**KIRKLEES COUNCIL
TOWN AND COUNTRY PLANNING ACT 1990
HIGHWAYS DEVELOPMENT MANAGEMENT**

PLANNING REF 2016/60/94118/E0/SH
CATEGORY Large Major

PROPOSAL OUTLINE APPLICATION FOR
RESIDENTIAL DEVELOPMENT

LOCATION LAND OFF RAVENSTHORPE ROAD,
DEWSBURY

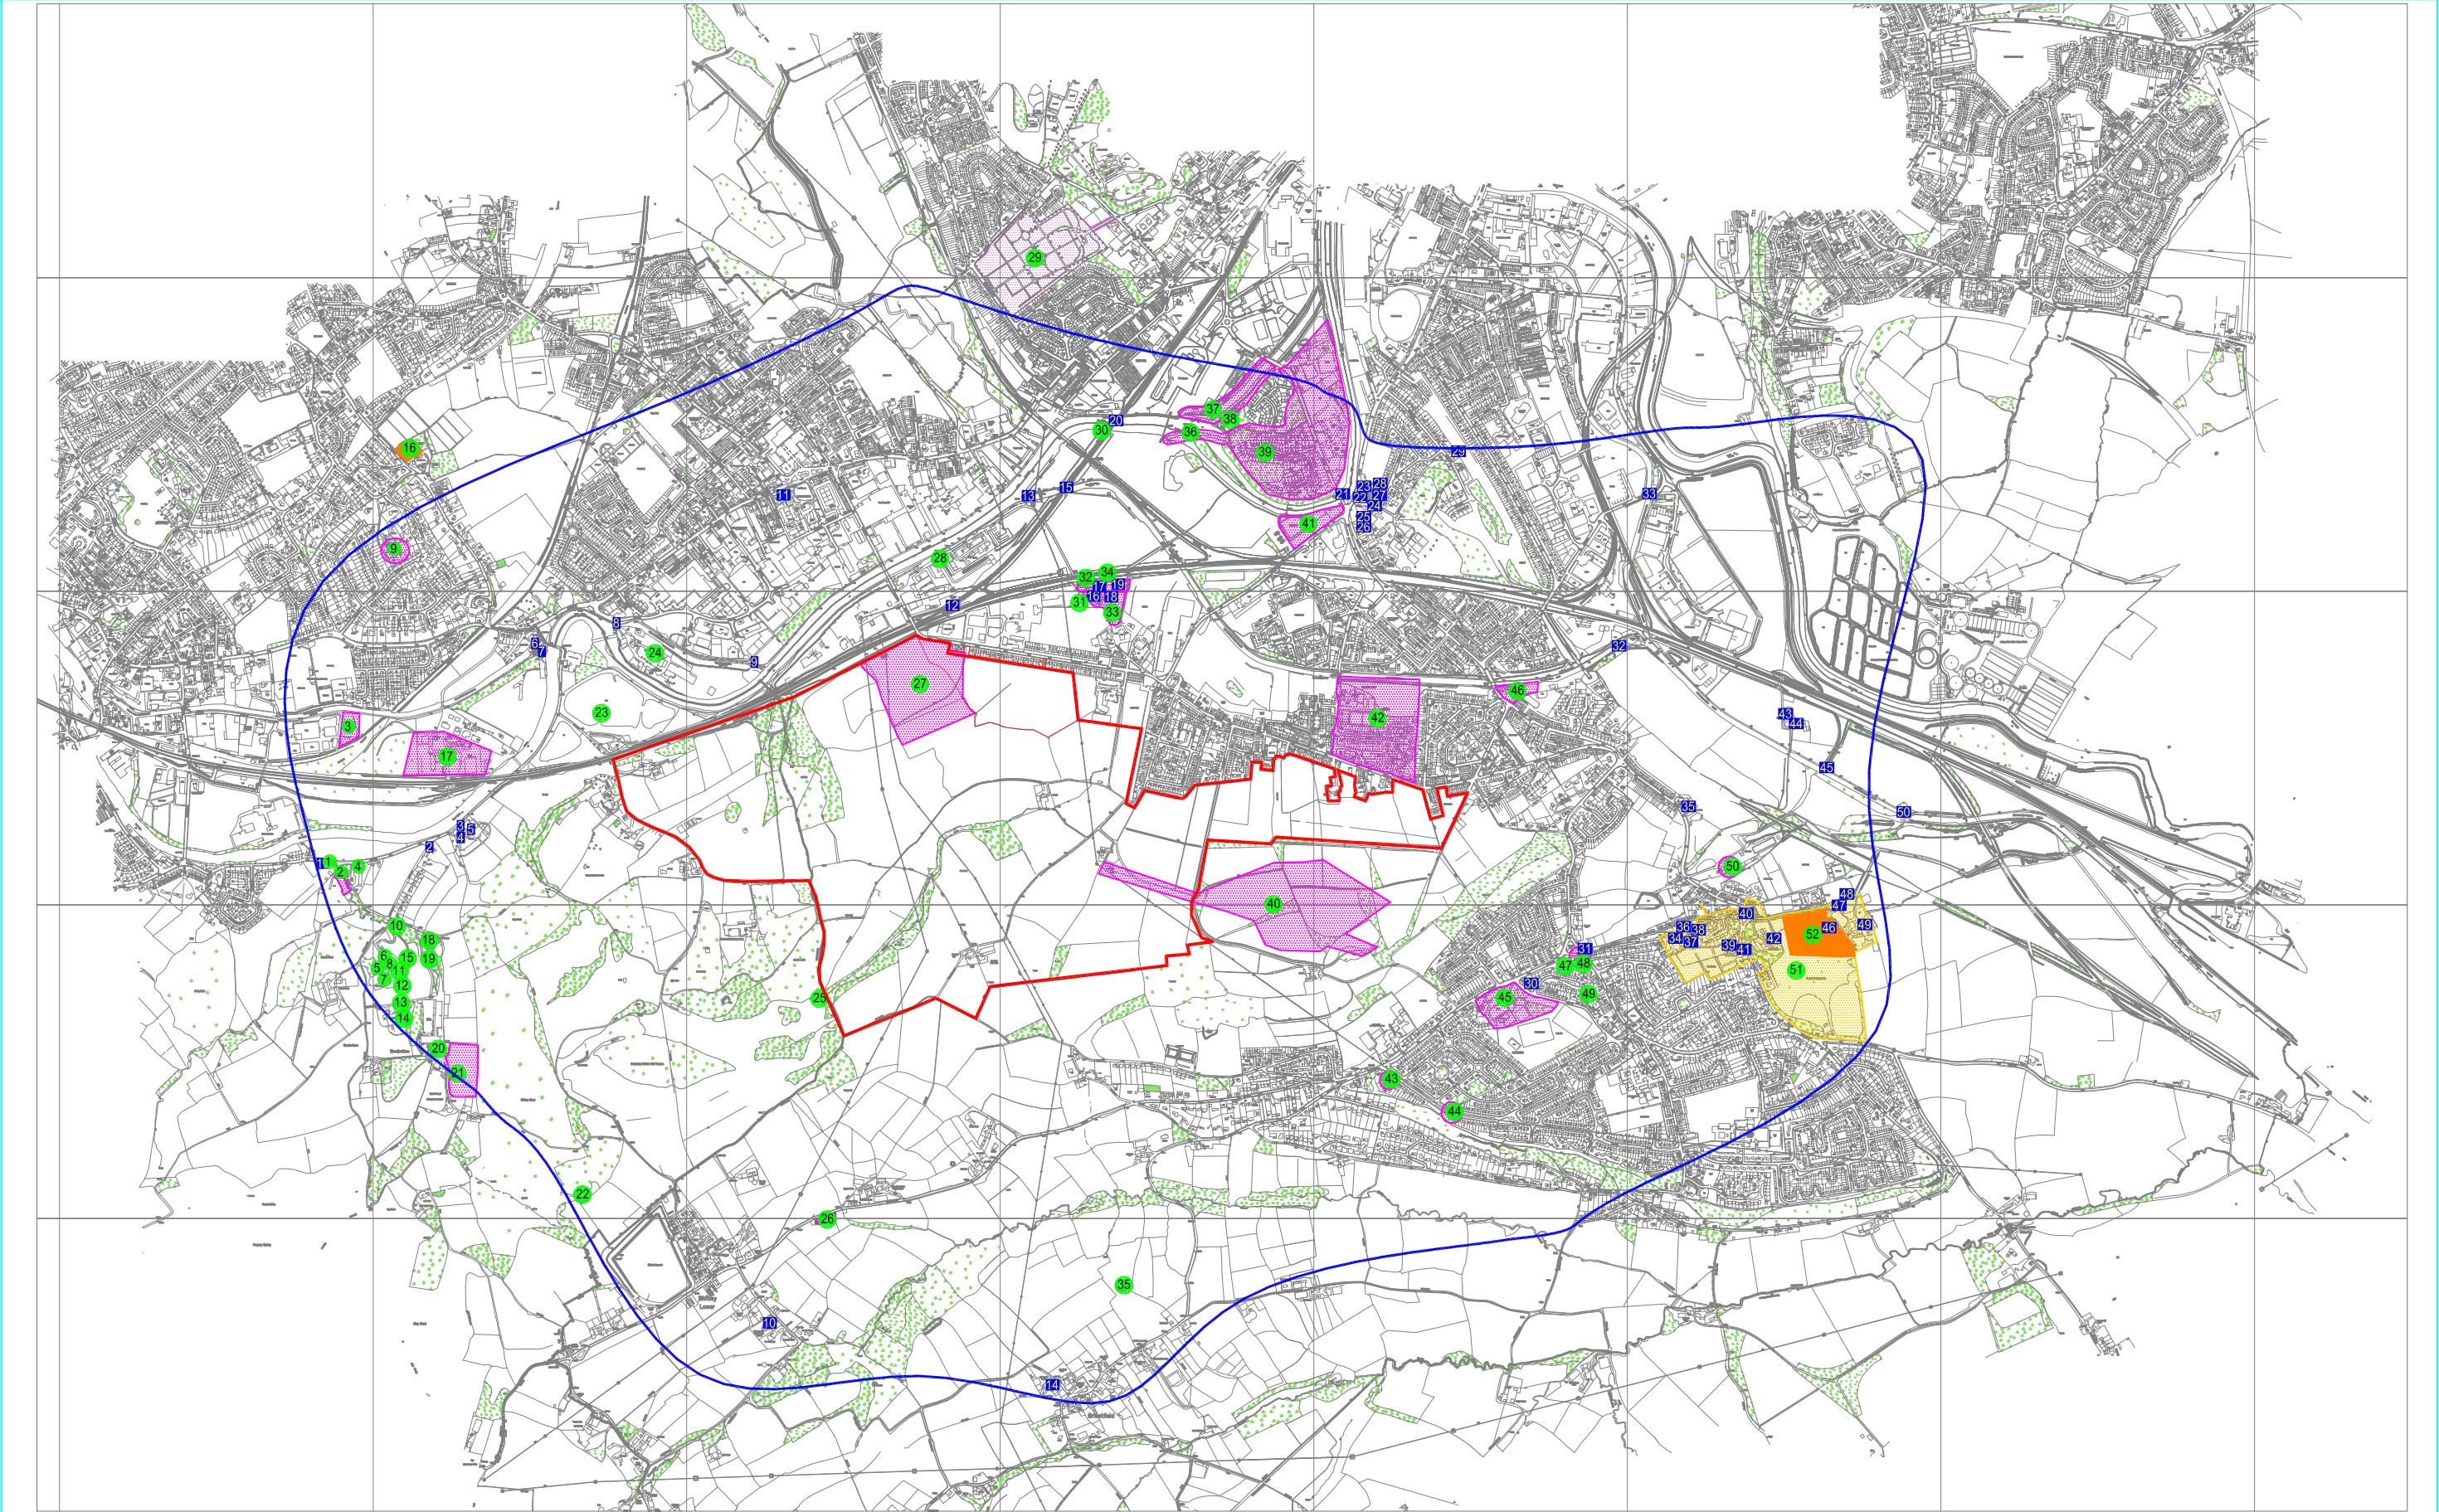
The existing access that provides vehicular access to the rear of 143-153 Ravensthorpe Road is currently unadopted. Rear access to these properties does not appear to be maintained on the Masterplan. Clarification from the applicant is requested in this regard.

The submitted Transport Assessment provides a study of existing pedestrian infrastructure within the vicinity of the site. The submitted Masterplan drawing illustrates a number of discontinuous footways. This should be addressed early in the design to avoid costly redesign at a later stage. There are no pedestrian crossing facilities shown on the Masterplan drawing and clarification from the applicant is requested in this regard.

There are two pedestrian access points proposed as part of the development. It is unclear from the submission as to what the status these access locations will be, however at a minimum, the footpaths should be offered for adoption. Currently these access points are used to access the existing land that the application site lies upon for agricultural purposes. It is also not clear as to how the remainder of the agricultural land will be accessed in the future post construction of the development. Clarification from the applicant is requested in this regard.

From the submitted information, it is not entirely clear which areas would be offered for adoption and which would remain private. This will need to be addressed early in the design of any reserved matters application coming forward.

There is no transition or delineation feature between the traditional estate road and the shared surface

area. Where ramps are placed to demarcate different surfaces, the footways should continue beyond the ramp to provide for level pedestrian crossing of the carriageway. Where ramps or other traffic calming features are proposed, they should be positioned to avoid creating or exacerbating captive low points.

The shared surface through route as presented should be reconsidered both conceptually and for conflicts with public highway.

There currently don't appear to be any publicly accessible visitor parking spaces provided within the shared surface areas of the development.

Some form of turning facility will need to be provided at all cul-de-sac locations within the site. Vehicles will be required to be able to both enter and exit carways, accessways etc in a forward gear. In addition vehicles should not be required to reverse past the house being visited (except to reverse into the plot driveway) in order to do so.

The turning heads as shown may not be sufficient to accommodate the turning envelope required by Kirklees Council refuse vehicles. Swept Path Analysis Vehicular tracking would need to be provided to demonstrate that refuse vehicles can enter and manoeuvre within the access roads in a safe and efficient manner. Kirklees Council would not expect refuse (or other service) vehicles to enter private roads or forecourts. However it is not clear where the refuse bins or bin collection points would be located. This is a particular concern for those plots not adjacent to the public highway. Bin pads and collection points will need to be located in accordance with Kirklees Council's "Good Practice Guide for Developers" document.

There are a number of open water channels within the development site. These channels may transfer water from outside of the development site. These channels are not shown on the Masterplan layout and it is not clear how they will be dealt with as part of the development.

There are no drainage details shown on the site plan drawing. There is however a "Dry Basin" shown. Consideration will need to be given as to its adoption.

The proposed trees within plot frontages should be repositioned so that the ultimate spread of the trees will not overhang the public highway areas.

TITLE: SITE ACCESS TO APPLICATION SITE FROM RAVENSTHORPE ROAD LONG SECTION ALONG PROPOSED SITE ACCESS
PROJECT: LAND OFF RAVENSTHORPE ROAD, DEWSBURY
CLIENT: MILLER HOMES

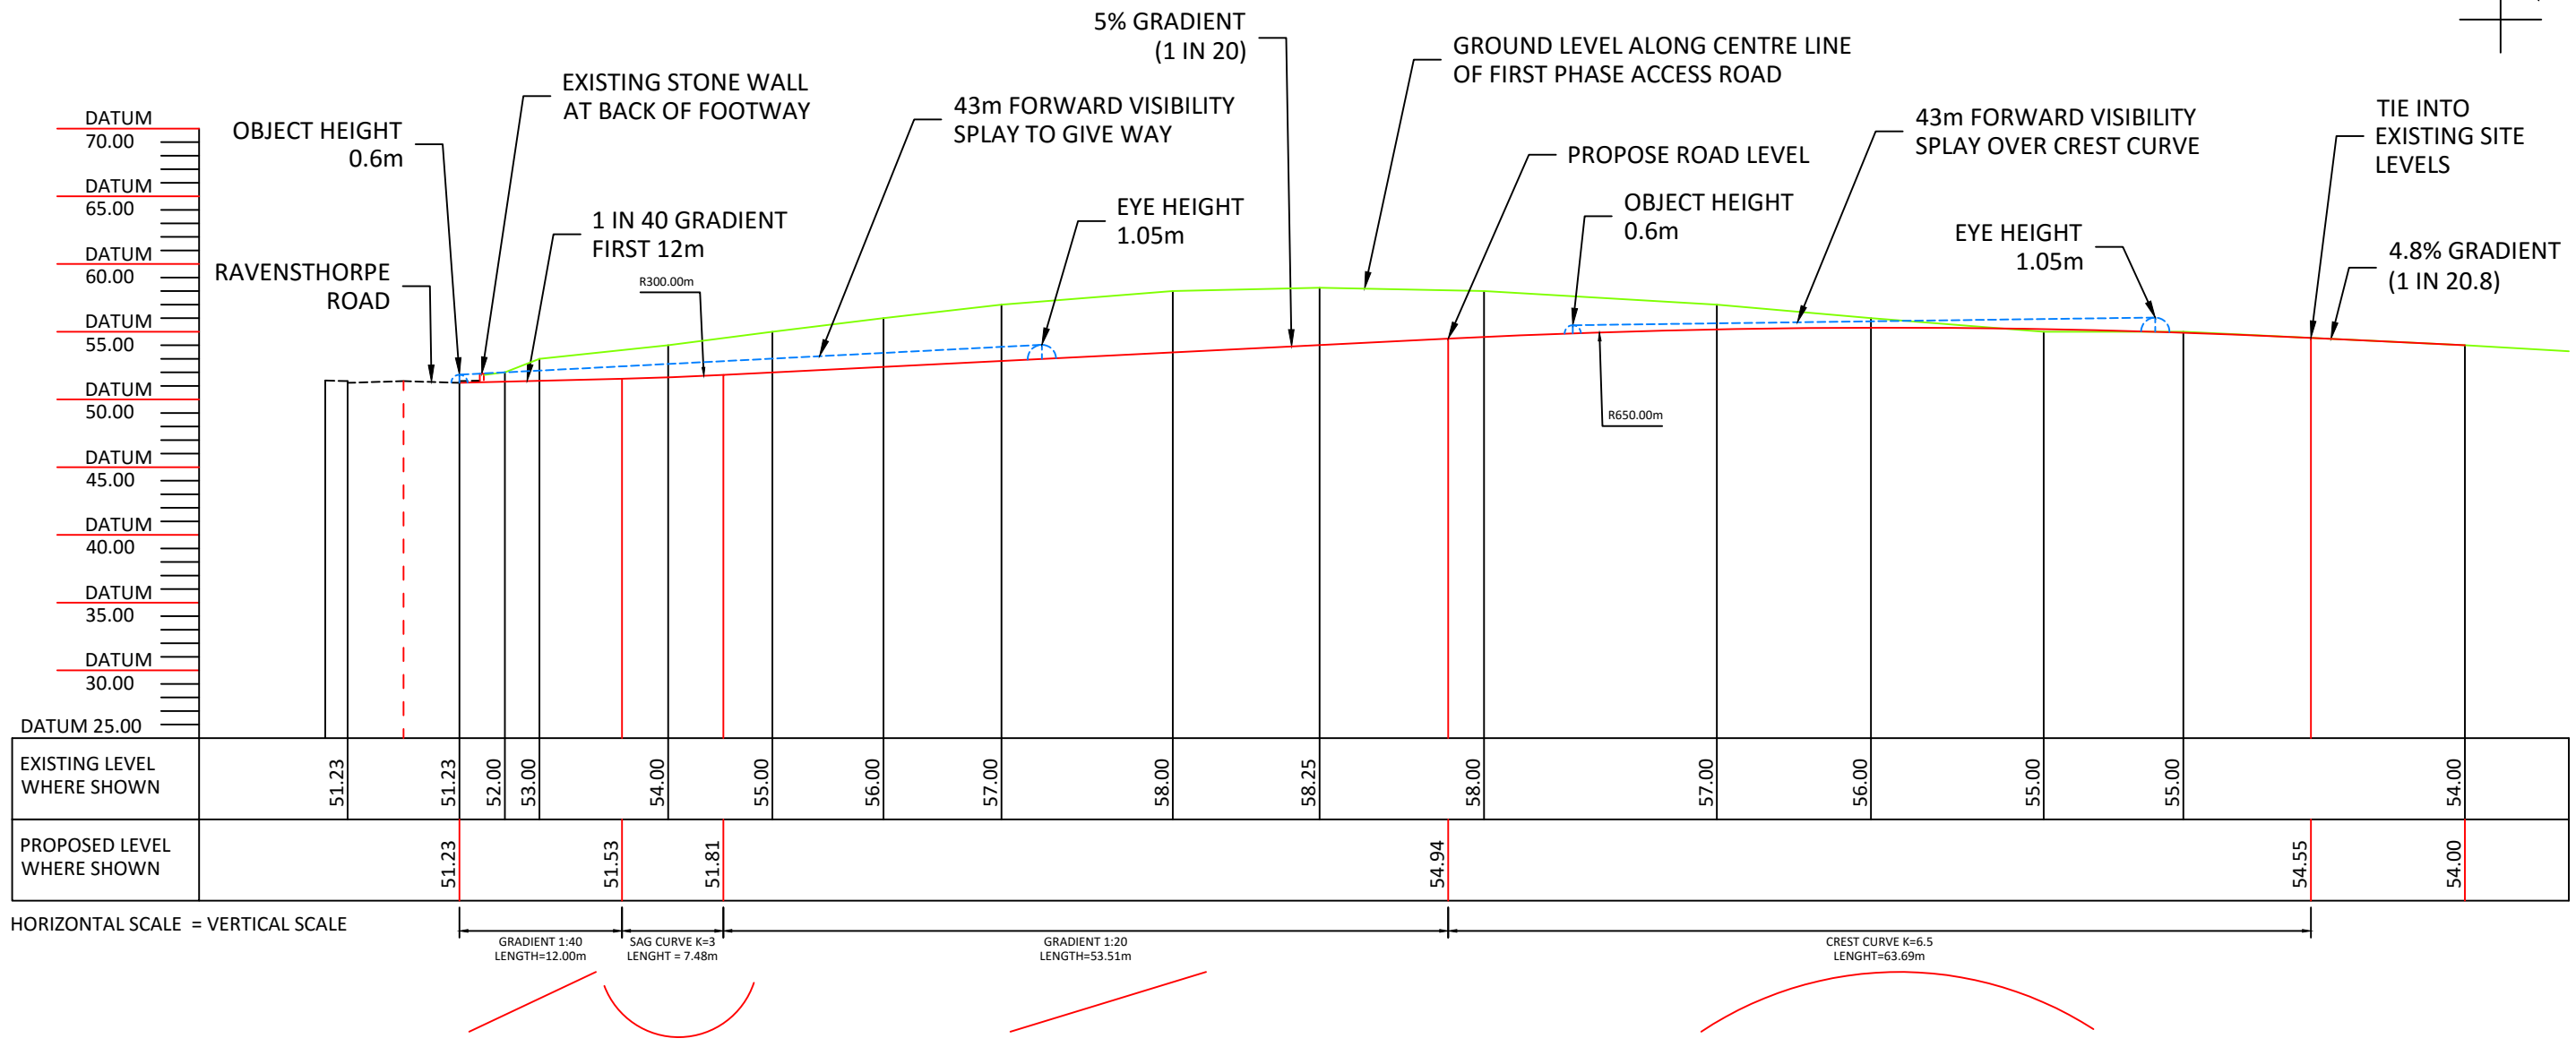
There are discrepancies between the two drawings regarding the proposed highway proposals. The site topography will have a significant impact on any access road alignment proposed. In addition there is a small retaining wall and relatively steep gradient southwards into the field. The extents of the earthworks required will similarly be affected by the location of the access road. Consequently, a somewhat more definite proposal that "Approximate location of spine road" should be required.

There are no levels or gradient information provided on either drawing. A section showing the site access road (including Ravensthorpe Road) would be required to fully assess the outline proposal at this stage.

It is not clear from the submitted site access drawing that the visibility splays to the east can be achieved as proposed. The proposed site levels may also impact upon the achievability of the visibility splays. Site levels may also impact forward visibility along the estate road.

The plots of the existing houses and current access points to the site are relatively flat. The proposed site however rises relatively steeply towards the southern boundary. Gradients will be an issue for all roads where they lie in a southerly direction.

It is noted that the submitted Transport Assessment states that [sic] "initial access gradients will be no steeper than 1:40 for the first 12m and 1:20 thereafter with suitable transition curves."

In terms of an outline proposal, this is considered acceptable in this regard.
